**WELWYN HATFIELD BOROUGH COUNCIL  
EXECUTIVE DIRECTOR - PLANNING, PUBLIC PROTECTION AND GOVERNANCE**

**Application No:** 6/2018/2300/LB  
**Location:** Oshwal Centre Coopers Lane Road Northaw Potters Bar EN6 4DG  
**Proposal:** Omission of 5 x rooflights from south-facing roofslope of extension  
**Officer:** Mr William Myers

**Recommendation:** Granted

DRAWING TITLE  
 OSHWAL REAR EXTENSION – MINOR AMENDMENTS TO ROOFLIGHTS PLANS, ELEVATIONS and SECTIONS

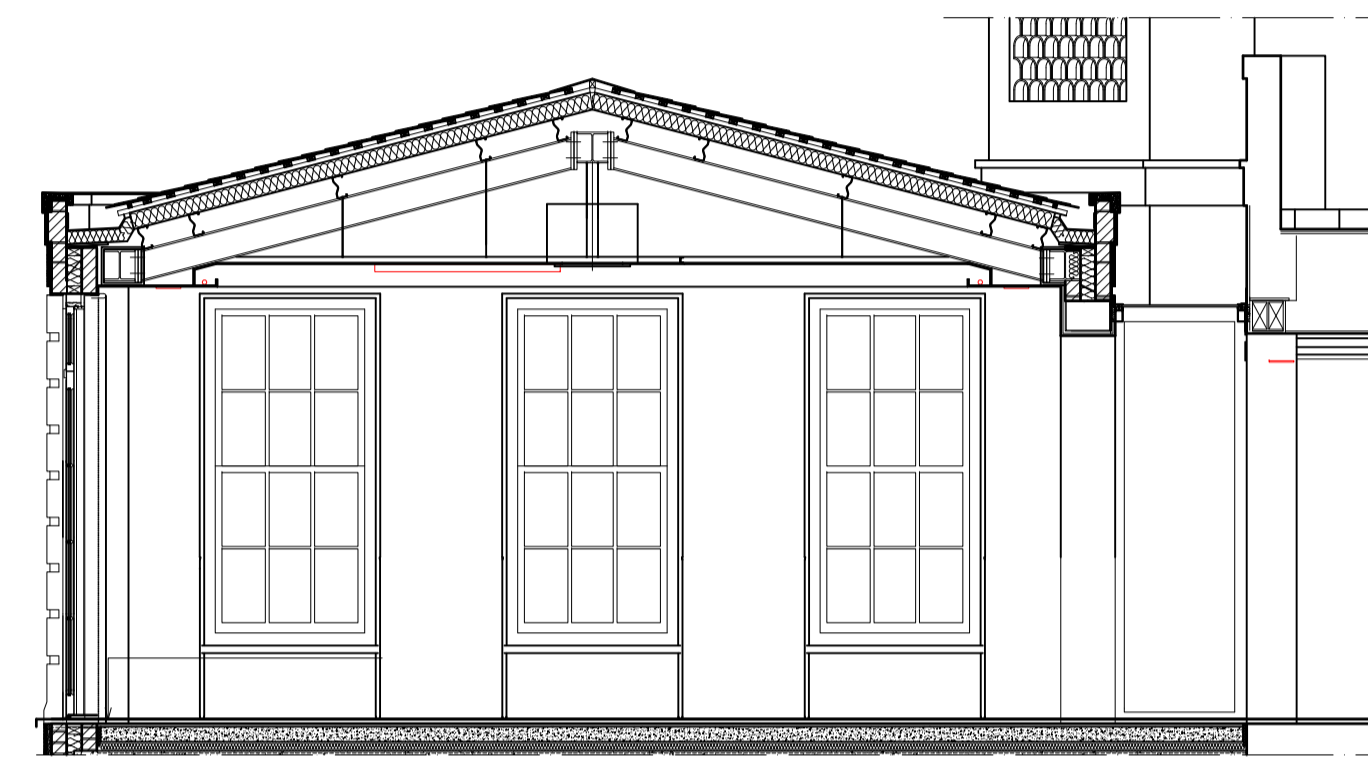
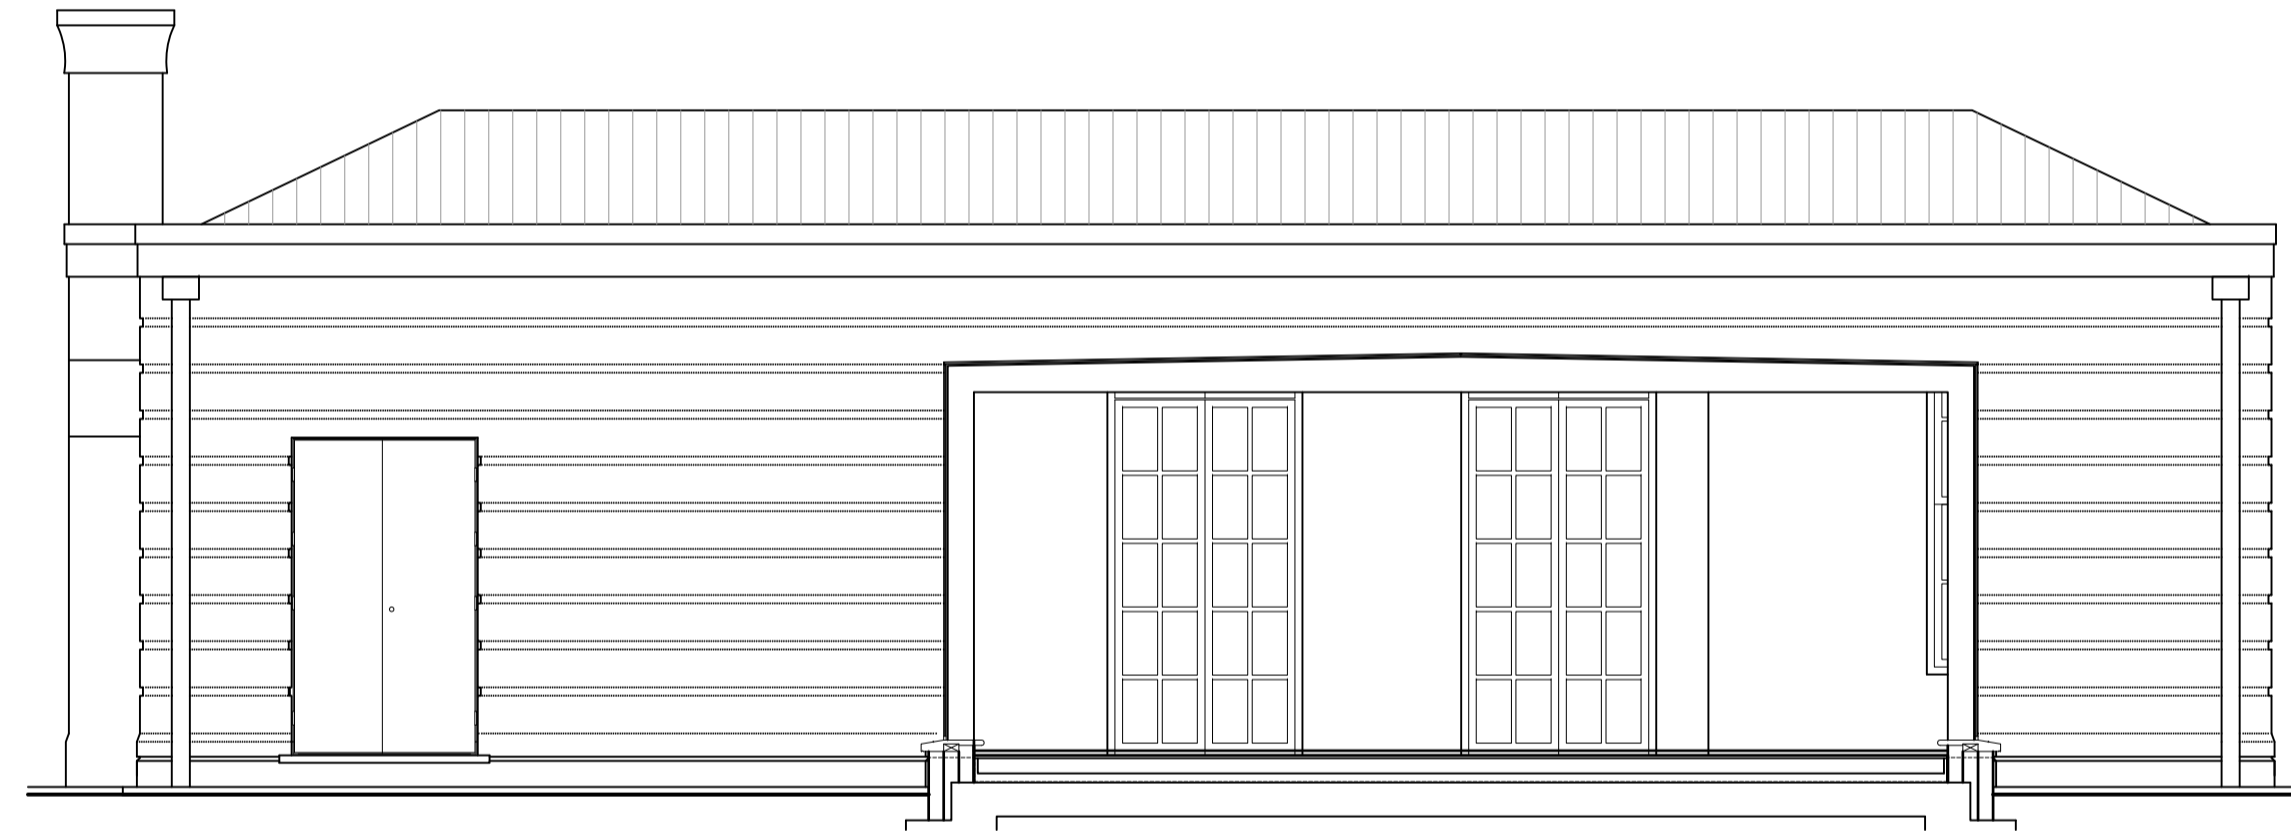
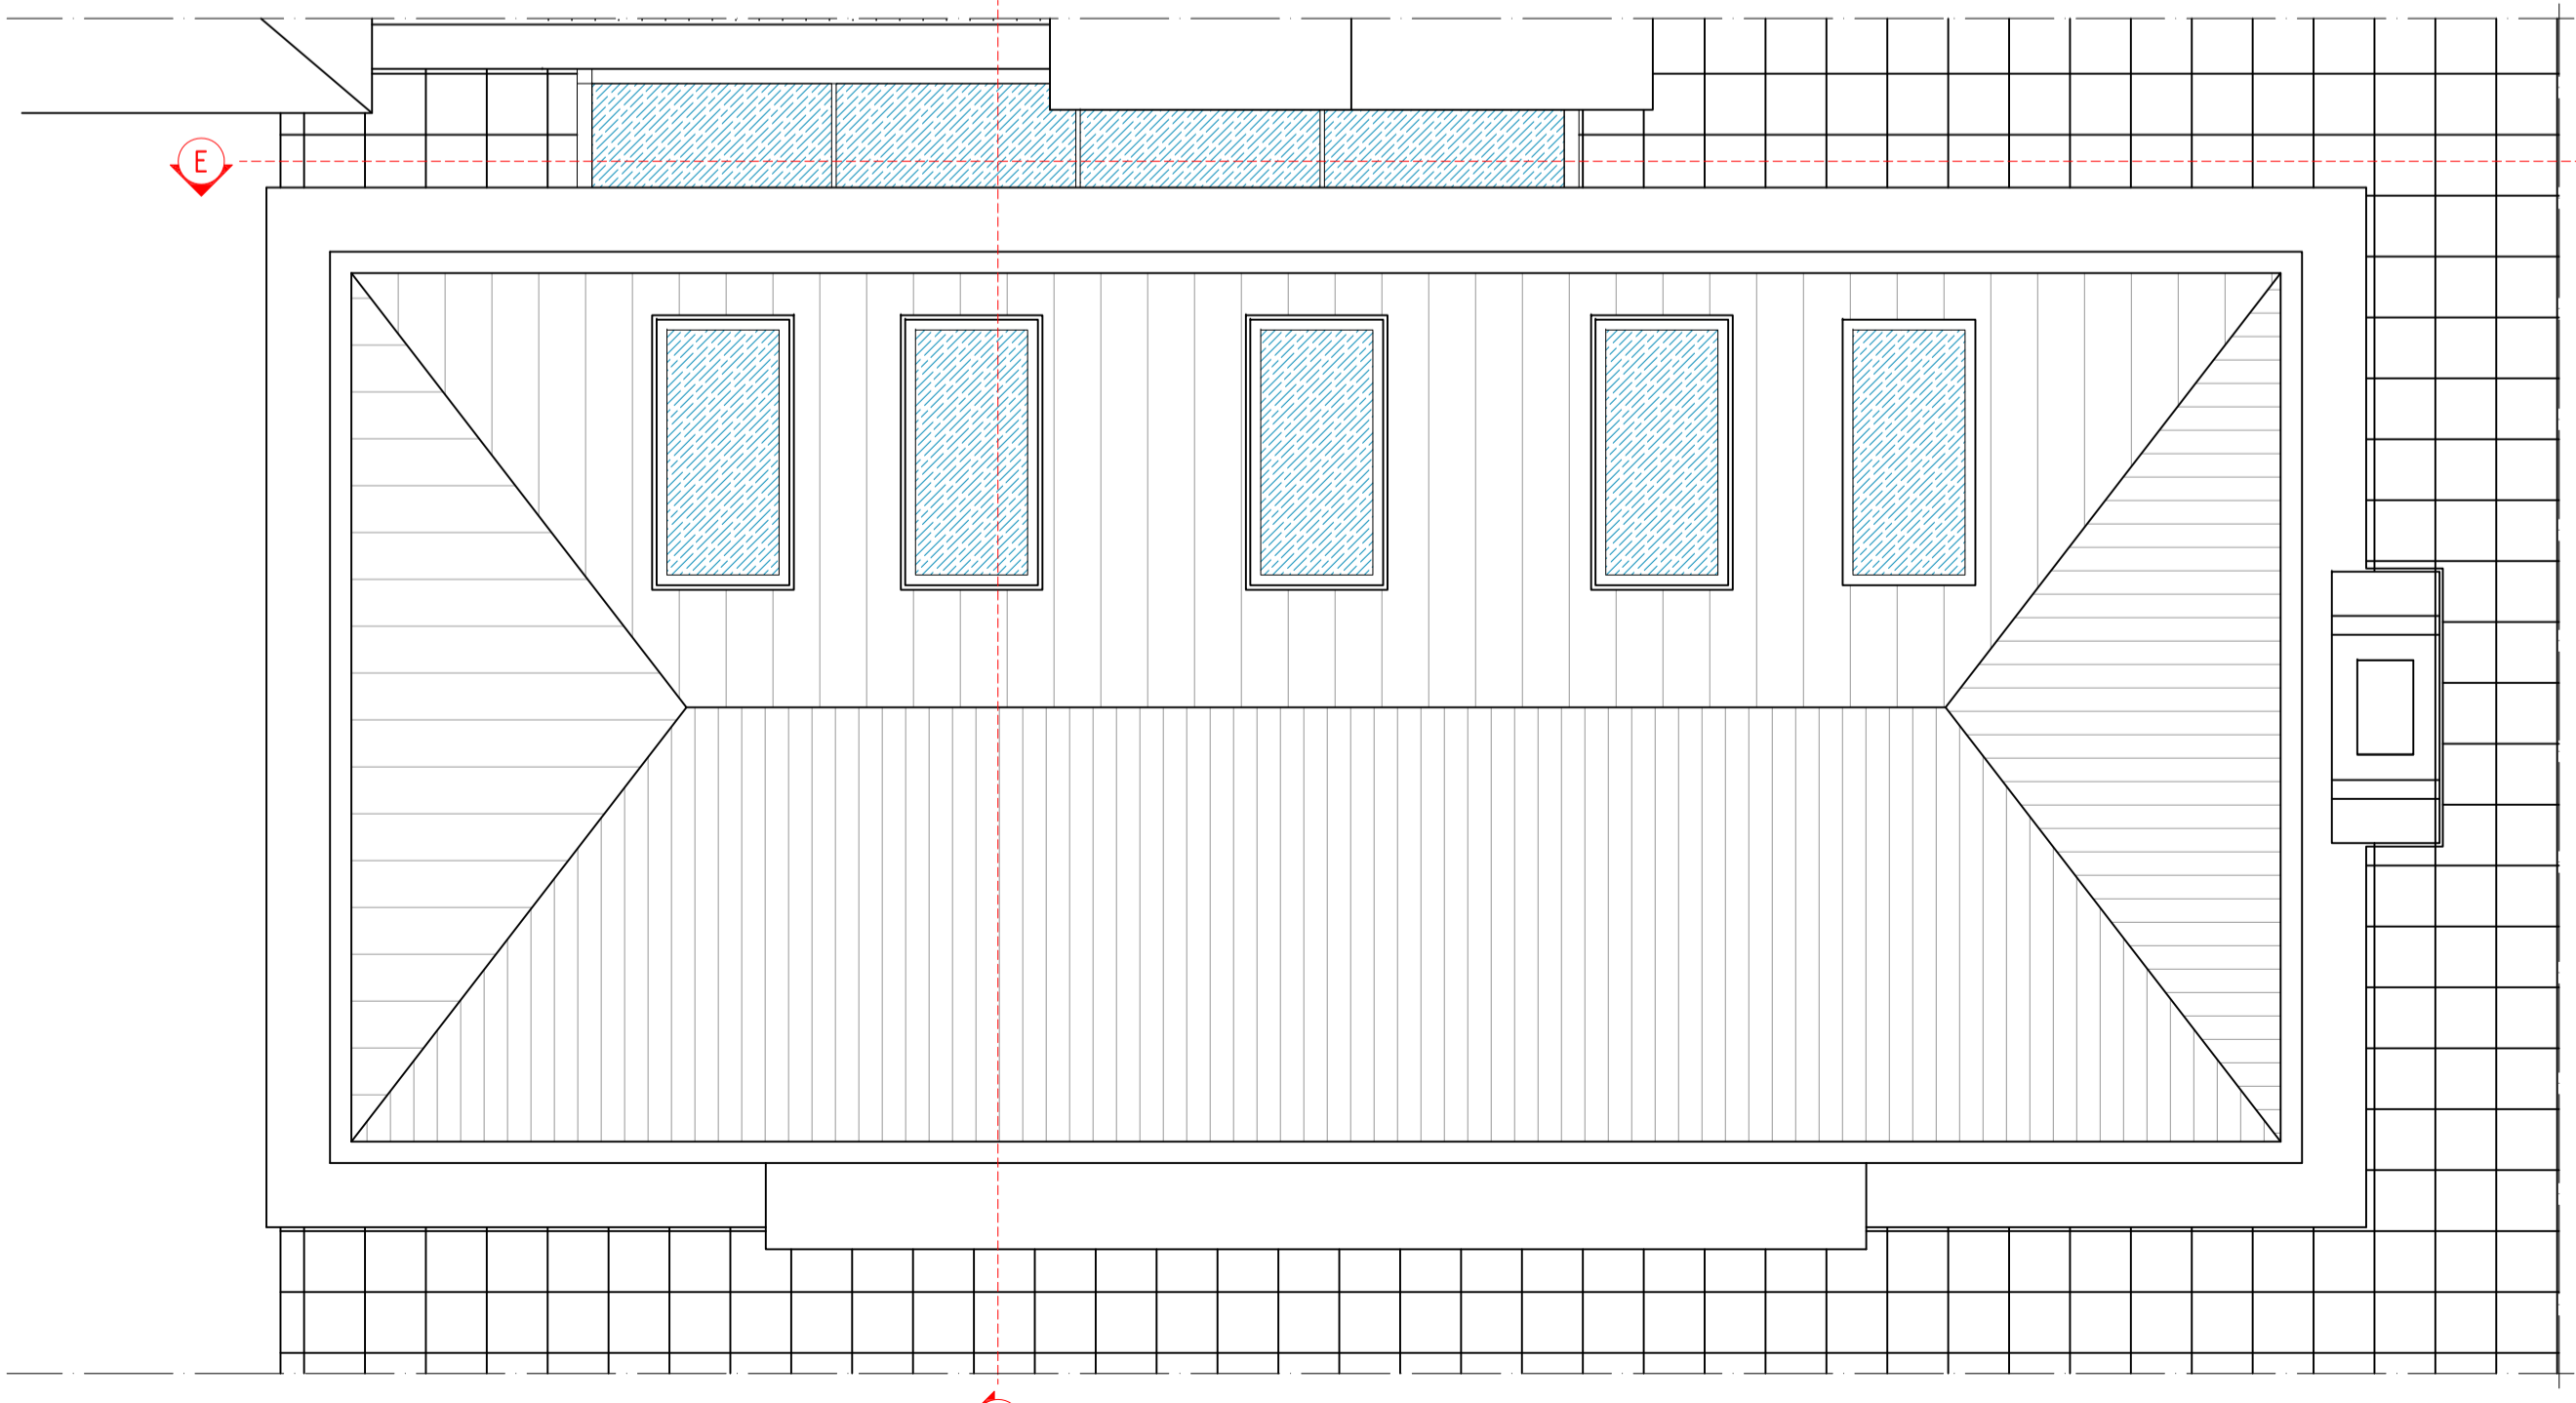
The omission of the rooflights on the south-facing roofslope (facing the rear of the house) of the new extension raises no objections. Their removal is considered to be an enhancement to the scheme as it simplifies the roof scape and the solid, uninterrupted roof is less of a visual distraction. It is therefore recommended that listed building consent is granted. No conditions are considered necessary.
<b>Any other considerations</b>	<i>Neighbour Objection</i>  It is noted that a neighbour has objected to the proposal on the basis of the activities that are occurring on the site and the amount of light that currently shines out from the site. As this application is for the removal of skylights, which were approved previously, it is not consider that the proposal would not result in an increase in the amount of light which would shine out of the site. In addition, as this application does not relate to the level of activities on site but simply the removal of skylights, it is not judged that the proposal would result in an increased level of activity within the site if the application were approved.
